Re: T.C.L. submittal for building permit approval for Allstate Claims Center,  
9400 Menaul Blvd. N.E., Snow Heights Addn., Block 31, Lot 24,  
[H20/D035], No Architect's Stamp.

The location referenced above, dated June 29, 2000, is not acceptable and requires modification to the Traffic Circulation Layout (T.C.L.) prior to Building Permit release as stated on the attached written comments and red-lined T.C.L. markup.

Written Comments: File #H-20/D035  
7/26/2000

ALL STATE - SNOW HEIGHTS GRADING AND DRAINAGE

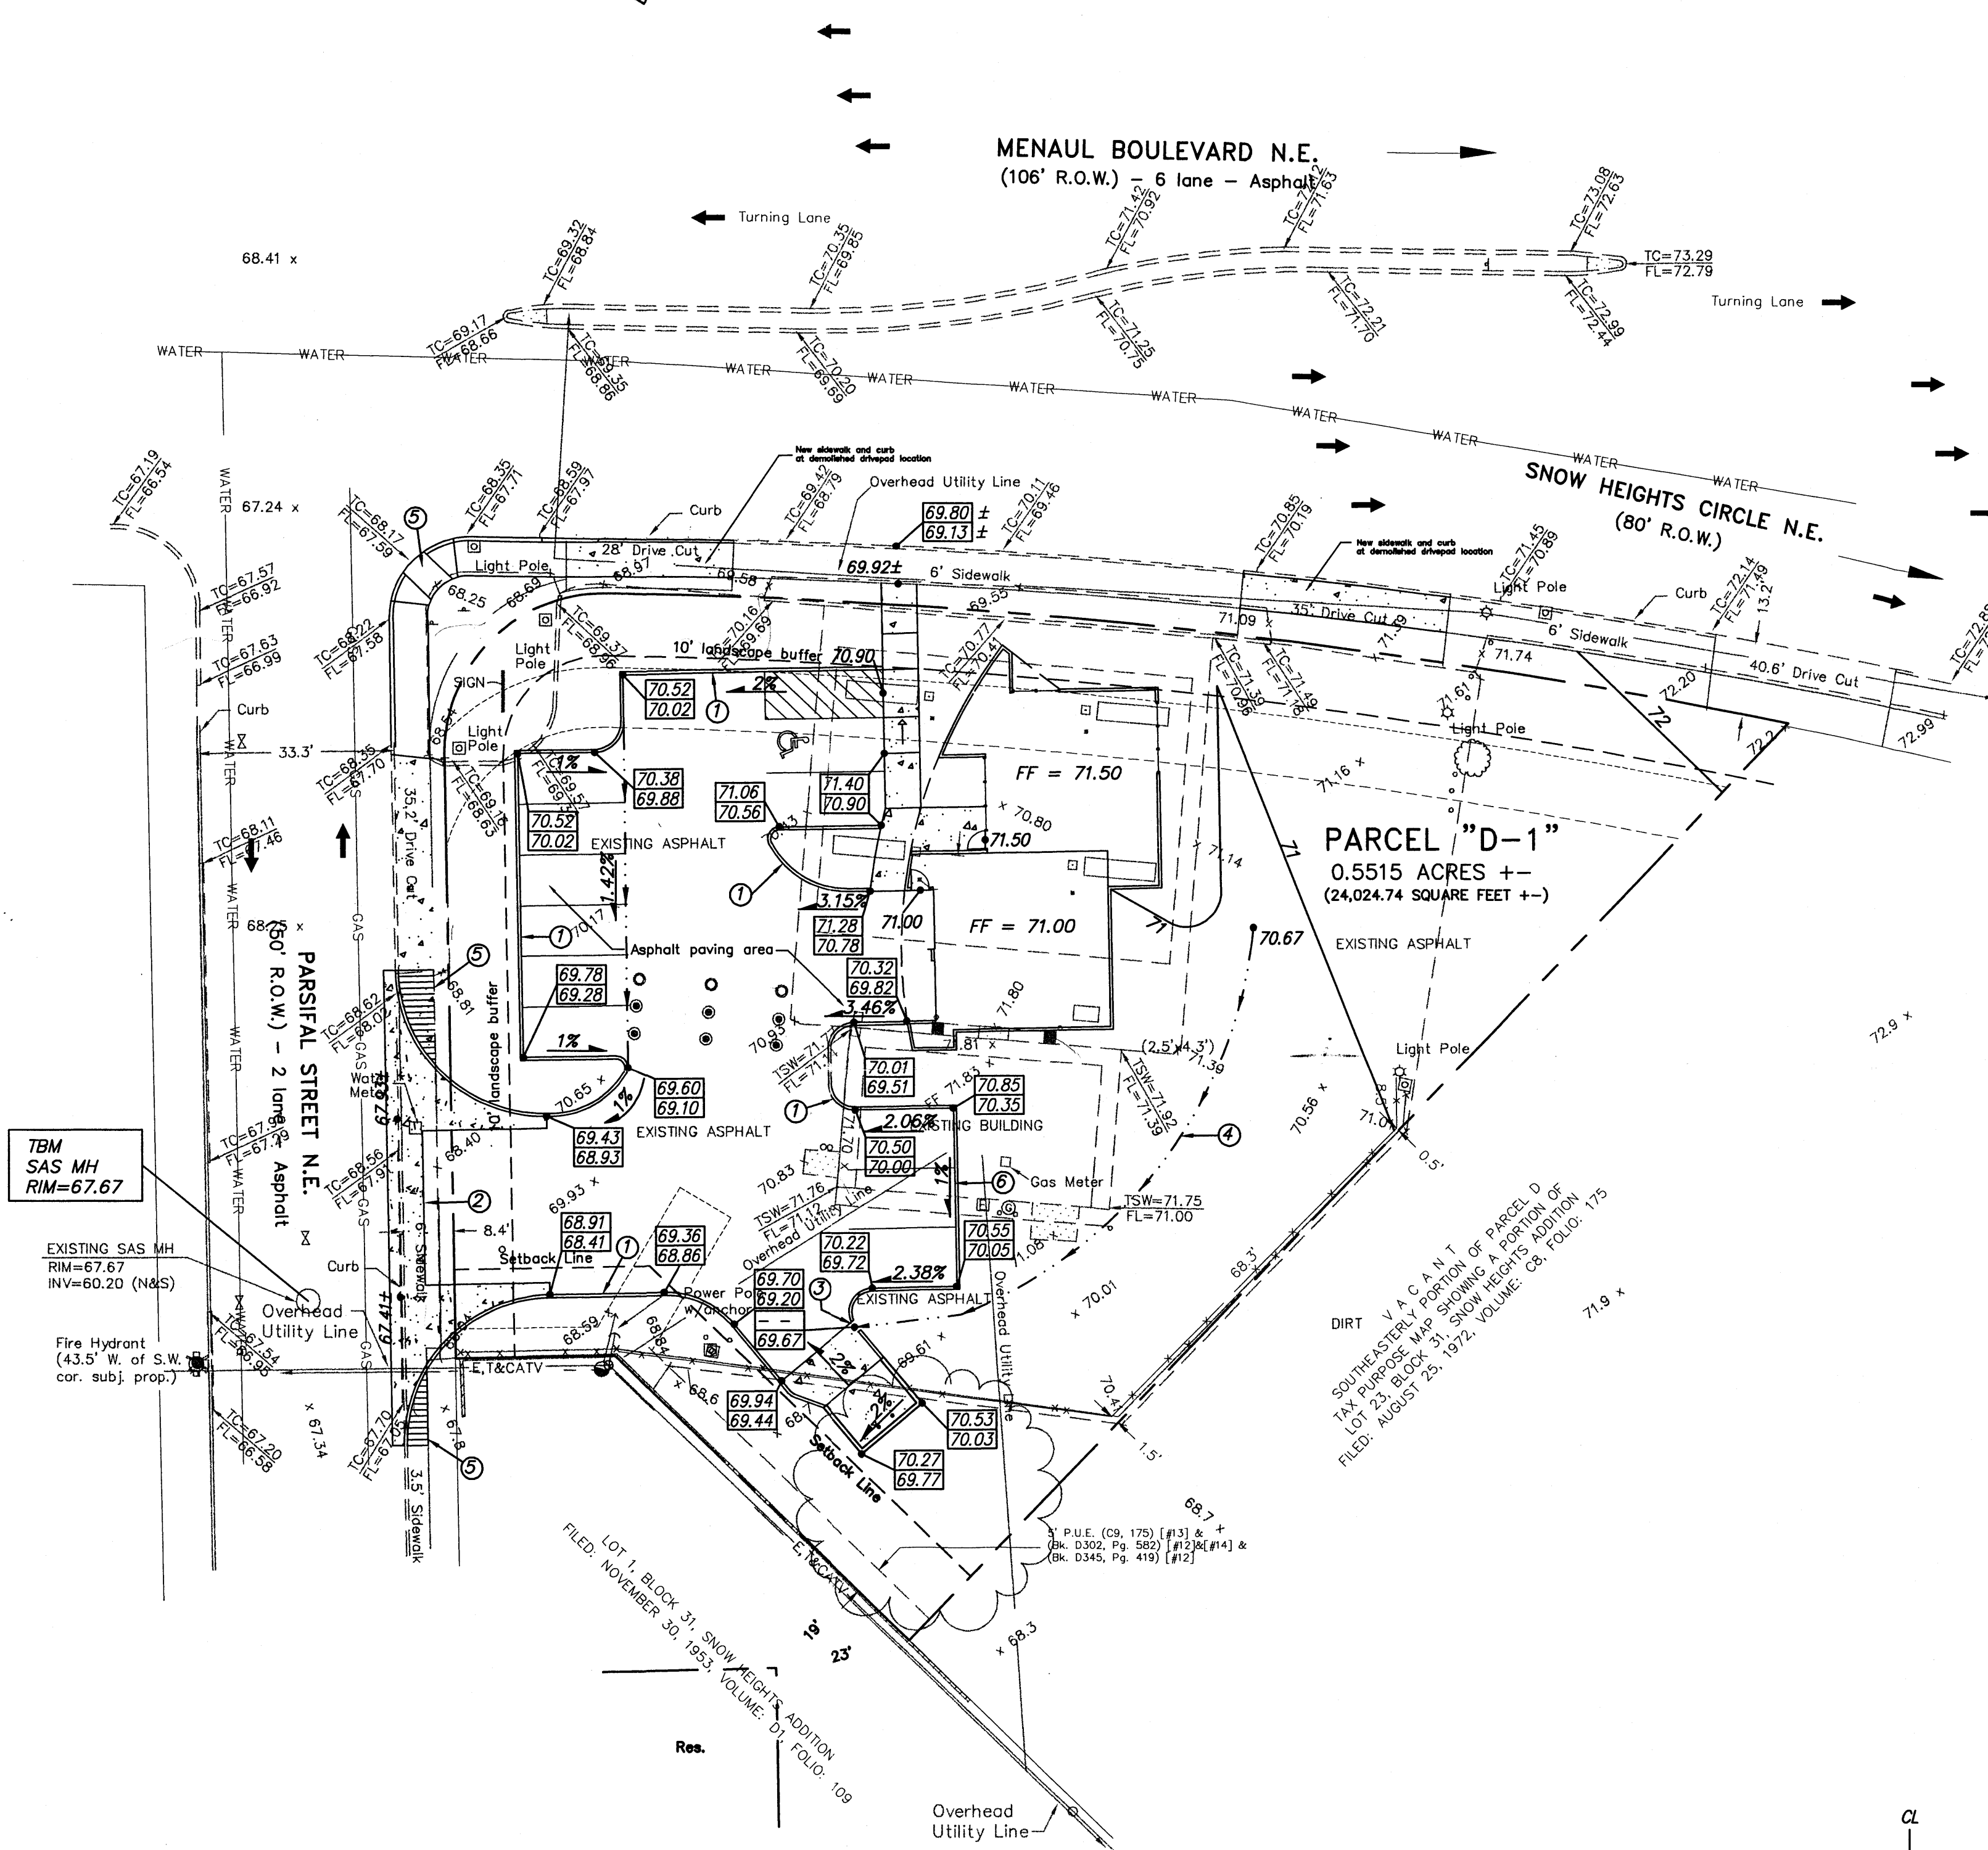
- Linework on Drainage Plan and Landscape Plan must match T.C.L. exactly. \_Confirm the acceptability of the changes in T.C.L. that are required by this office with Hydrology. \_If minor changes are acceptable to Hydrology, call out on T.C.L.: INSPECTION OF CONSTRUCTION FOR C.O. FOR TRANSPORTATION WILL BE DONE FROM THIS SHEET.
- Show and label new or existing H.C.ramp at street corner, must be A.D.A.For future reference, show half width of all streets 40' wide and over on T.C.L, unless shown and dimensioned on Grading and Drainage Plan. This is to include: (1) median and opening, if it exists (including any left turn lanes into this site). Without medians show traffic lanes up to and including middle turn lane. (2)all existing/new standard curb and gutter.
